# Longfield Solar Farm

Statement of Common Ground – Environment Agency

Document Reference-: EN010118/EX/8.4(A)

~~August~~ [September 2022](#)

Figure 3 : SFRA Fluvial Flood Zone Mapping 65% Climate Change - Fluvial Modelling Report

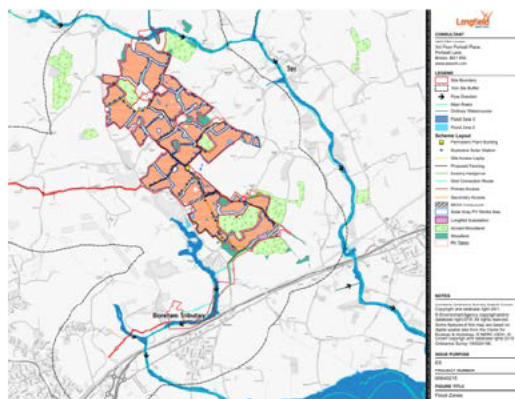
Ref	Sub-topic	Stakeholder Comment	Applicant's Response	Status
		<p>However, in light of the requirements in paragraph 4.8.8 of EN-1, it cannot be ascertained accurately from the information provided whether there is any risk to critical parts of the infrastructure without knowing what levels these are set at and what the flood level would be for the 0.1% AEP plus the maximum credible climate change uplift values to peak river flows.</p> <p>The FRA should assess if further modelling is required to establish flood levels noting the requirements of the NPS EN-1 4.8.8 and the requirement to establish the 0.1% AEP plus the maximum credible climate change uplift values to peak river flows.</p> <p>Whilst this may seem negligible, it is currently unknown what flood level this represents and how infrastructure could be affected. Infrastructure should be 'designed and constructed to remain operational and safe in times of flood' as required by the 'Flood and Coastal Change' guidance document.</p> <p>It needs to be clear from the applicant's documentation and risk assessments as to whether there are any features of the infrastructure that are critical to its operations close to the boundaries of the flood zones. If there are critical elements of the infrastructure close to the boundaries of FZs 2 and 3 then the 37% peak river flow uplift should be applied.</p> <p>This should be through hydraulic modelling of the River Ter and Boreham Brook (tributary). [Statutory consultation and Relevant Representation]</p>	<p>The level of 48m AOD is not reached on the right bank of the water course for approximately 1km. With a smaller river catchment than the River Ter (614ha, 87% smaller) in this location, it is considered flood levels will not have capacity to reach 48m AOD across such a width.</p> <p><b>Appendix 9A Flood Risk Assessment [EN010118/APP/6.2]</b> discusses this in more detail.</p> <p>Given all PV panel installations and other above ground structures, buildings or equipment are in Flood Zone 1 no further modelling has been undertaken. Justification and plans to support the approach have been provided in <b>Appendix 9A Flood Risk Assessment [EN010118/APP/6.2]</b>, including a plan showing the Scheme and Flood Zones (Figure 3).</p>

12	<b>Development areas and Flood Zones</b>	Appendix A of the FRA shows the layout of the development. It should also have a map showing built development in relation to the flood zones (including climate change, for the lifetime of development and beyond, as a sensitivity test). [Statutory consultation]	The updated FRA is available in <b>Appendix 9A Flood Risk Assessment [EN010118/APP/6.2]</b> . Figure 3 shows areas where above ground development may be located in relation to Flood Zones.	Agreed
